Application No: M/86/20/PL
Site Address: 8 Manor Way Elmer Middleton-On-Sea PO22 6LA
Description of works: Demolition of existing 2 storey dwelling and construction of new 2 storey 4 bedroom dwelling with habitable loft and all associated works. This site is in CIL Zone 4 and is CIL Liable as new dwelling.

Thank you for your internet representation made on 24th December 2020 which has been recorded as an objection with the comments as follows:

Proposed Elevations

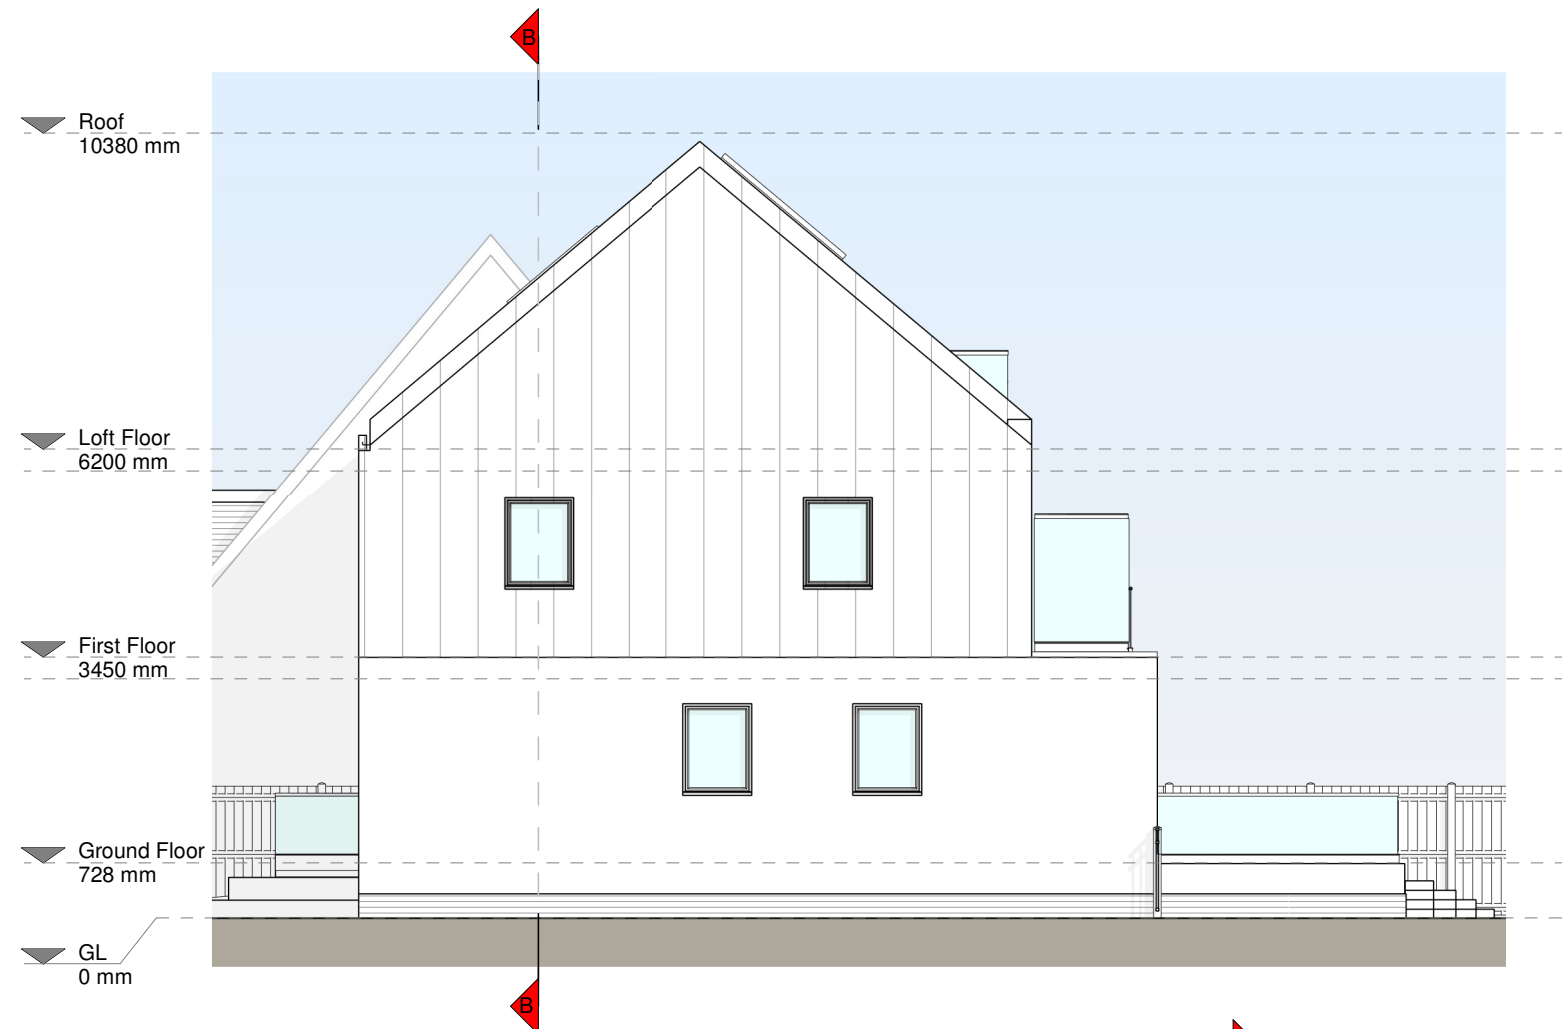
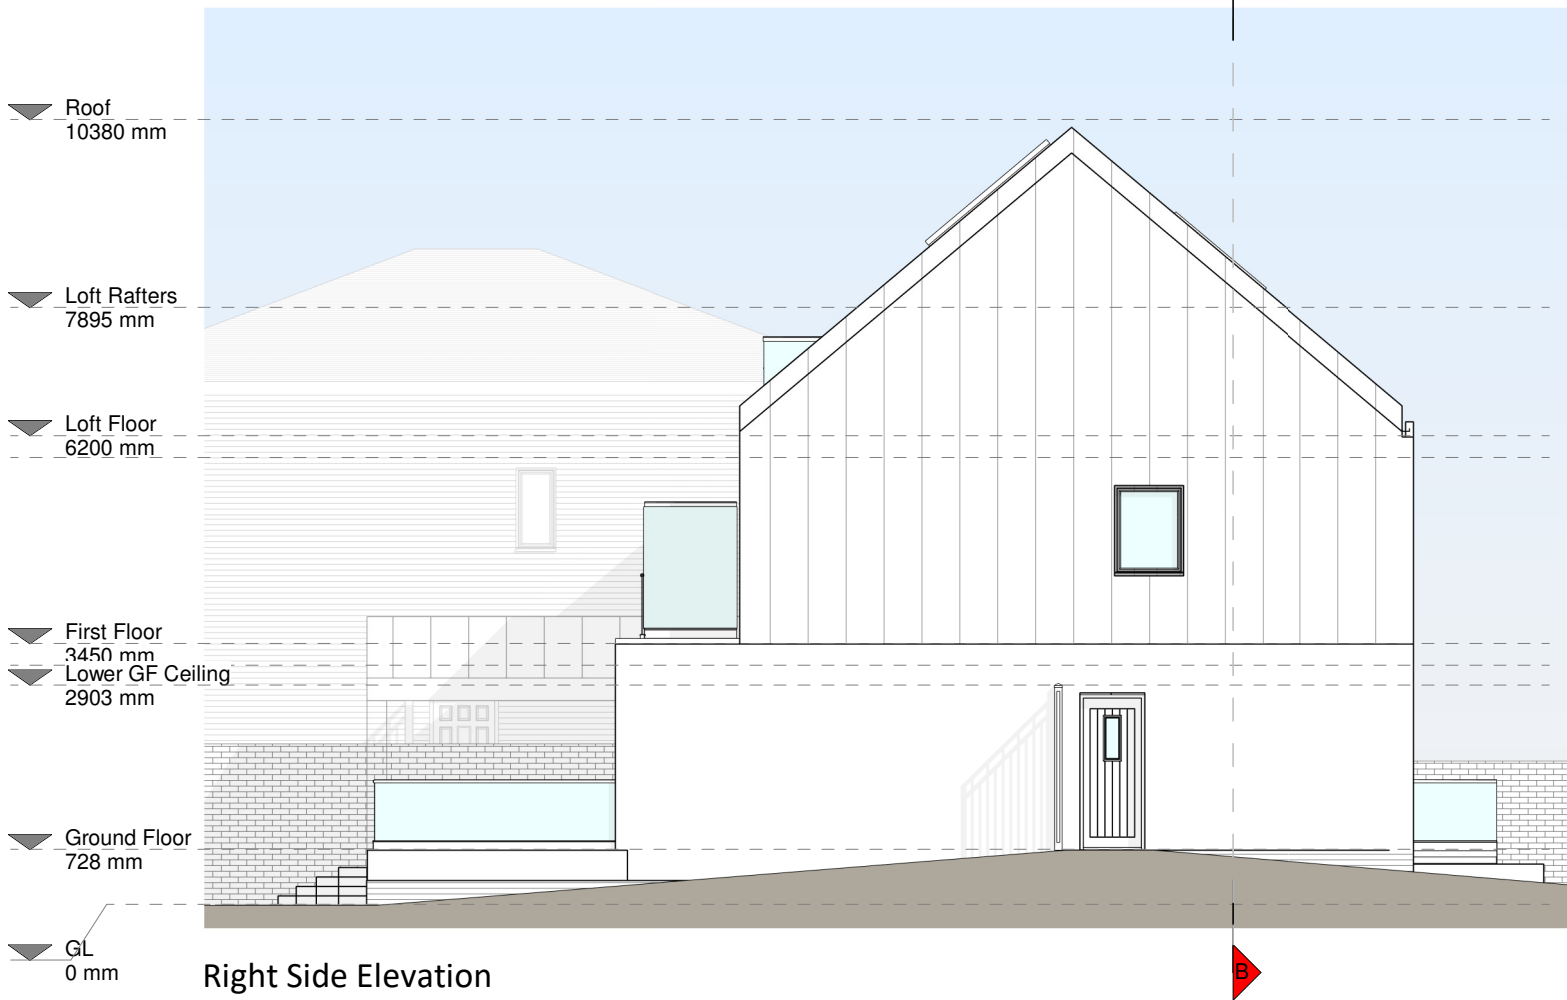
Whilst I do not object to the refurbishment or rebuild of No8, I am concerned this 3 storey design is out of character for the area. There are no three storey buildings in the immediate area and the overall design will look very radical and over bearing from the sea front when compared to neighboring properties. Where there are 3rd stories in Middleton these are limited to dormer windows in the roof. There is no side screening shown on the 1st floor balcony which should be a planning condition and the second floor balcony will be very un-neighboring and cause severe overlooking of nearby properties.
